R.E: Planning Application 2021/60/94410/W

In December, we received a letter notifying us of a planning application for a residential property on Olney Street

Site Plan 1:500

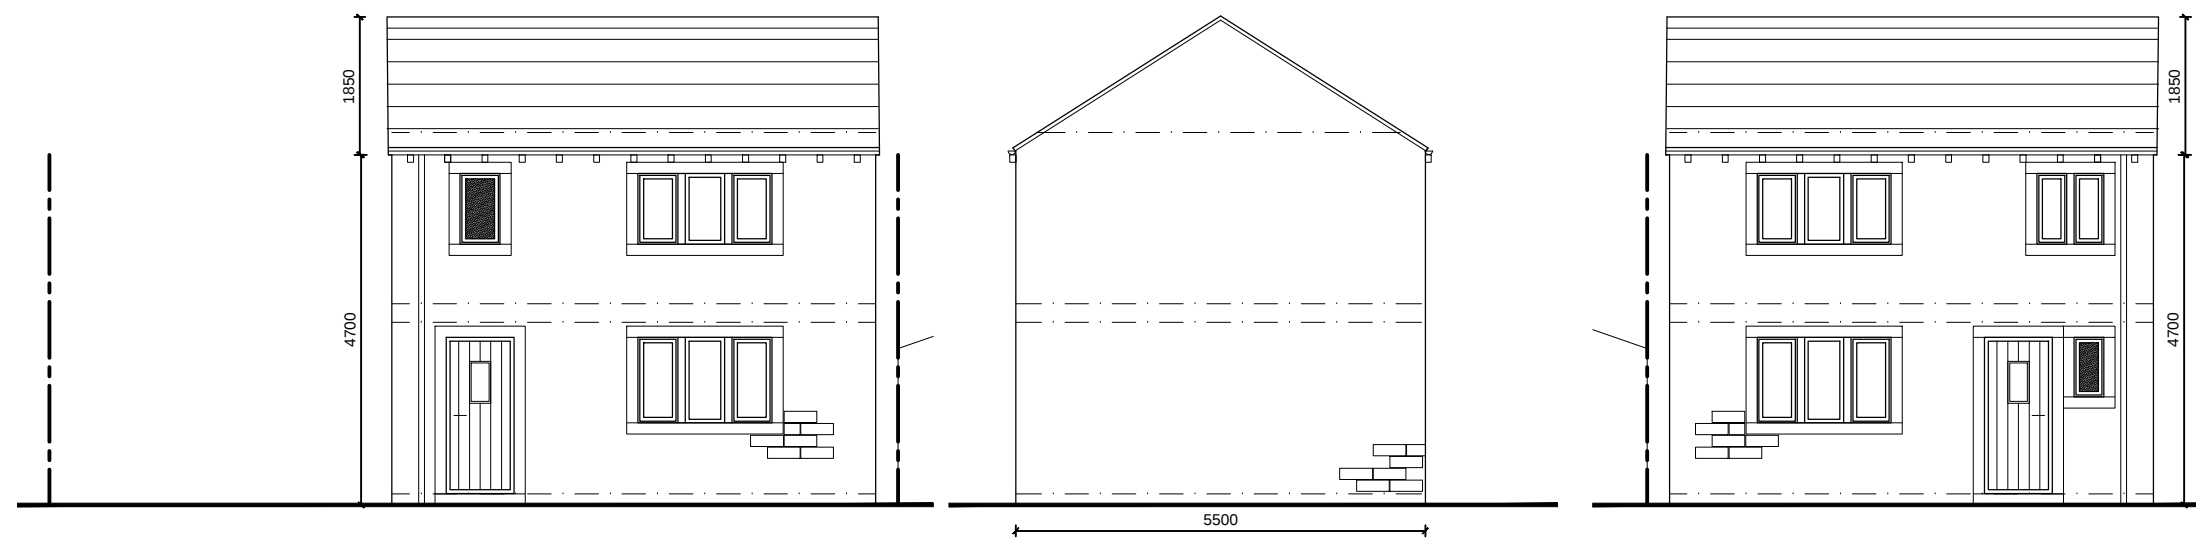
- Olney Street is already very congested with residents' parked cars.
- The space in front of the garages, where the proposed property would be, is a critical vehicle turning area for many people
- By removing this turning space, we feel it would cause issues for larger vehicles such as the residents with vans who currently park at the side of the proposed plot, delivery drivers, bin lorries, emergency services, etc. It's likely that such larger vehicles would need to reverse all the way back down Olney Street to be able to get out of the street, which we feel poses a risk to other parked vehicles or children playing on the street.

- The drawings provided don't appear to be to scale, and there's no scale bar, so it's tricky for us to understand the actual size of the proposed property.
- From what we can see, the property appears to be really small and we're not sure if it complies with national space standards for a residential dwelling.
- The double parking space also looks too small to comfortably accommodate two cars.

Front Elevation

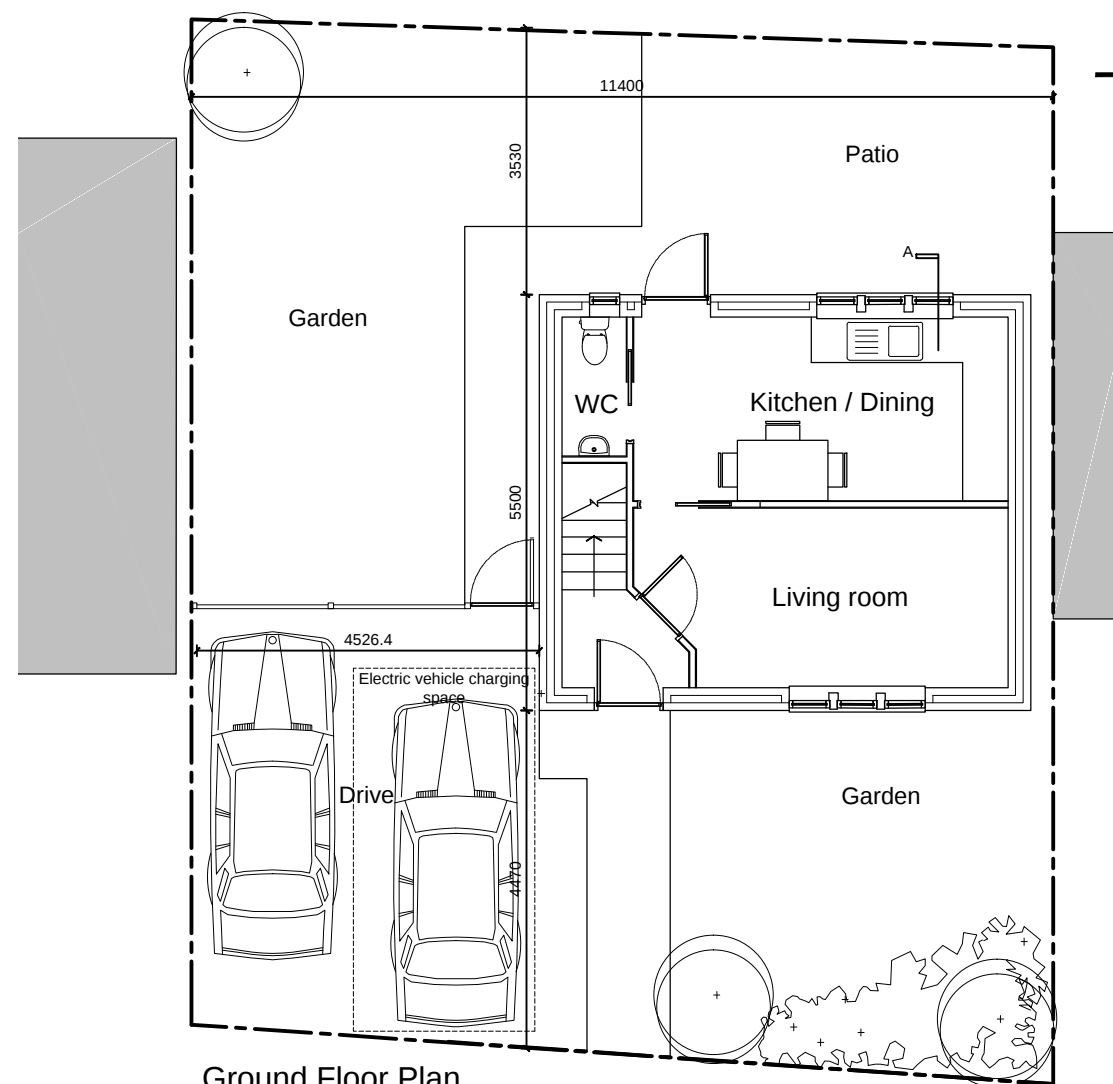
- The properties on the same side of the road leading up to the proposed plot are all single storey bungalows, then a row of garages. It would seem strange to have a taller, 2-storey property placed in the middle of single-story properties.
- We feel that the proposed property would be in a strange position and 'squeezed' into a small space between an existing row of garages and parking spaces, which doesn't feel like an appropriate setting for a residential property.
- The proposal seems advantageous to build a 2-bedroom dwelling and a double-driveway on such a small plot of land.

Ground Floor Plan

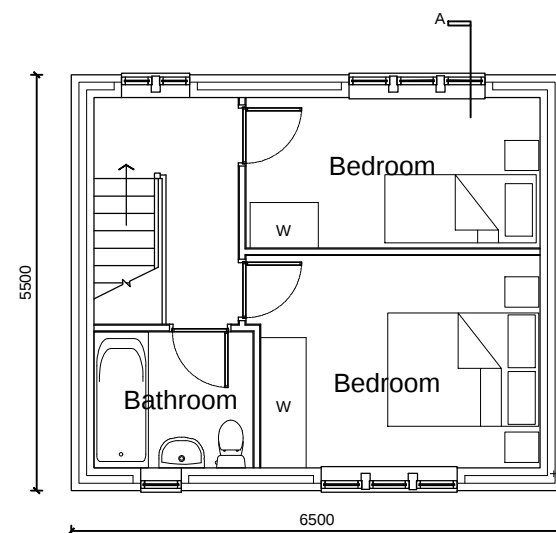
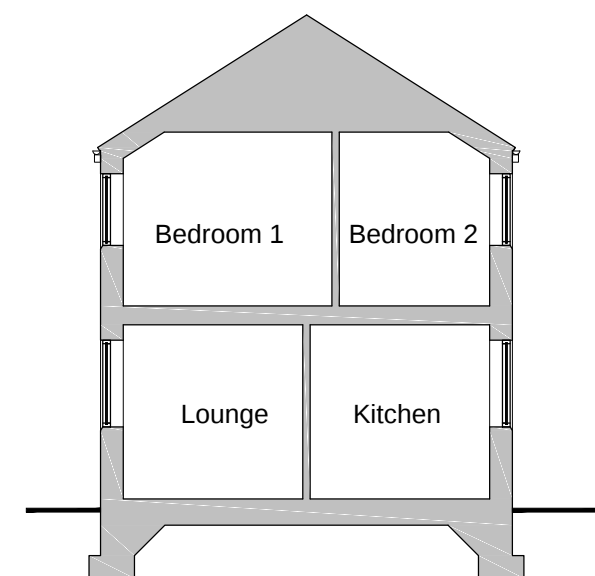
- There would be a direct viewpoint from the proposed property, particularly from the upstairs of the proposed property, which would have viewpoints into
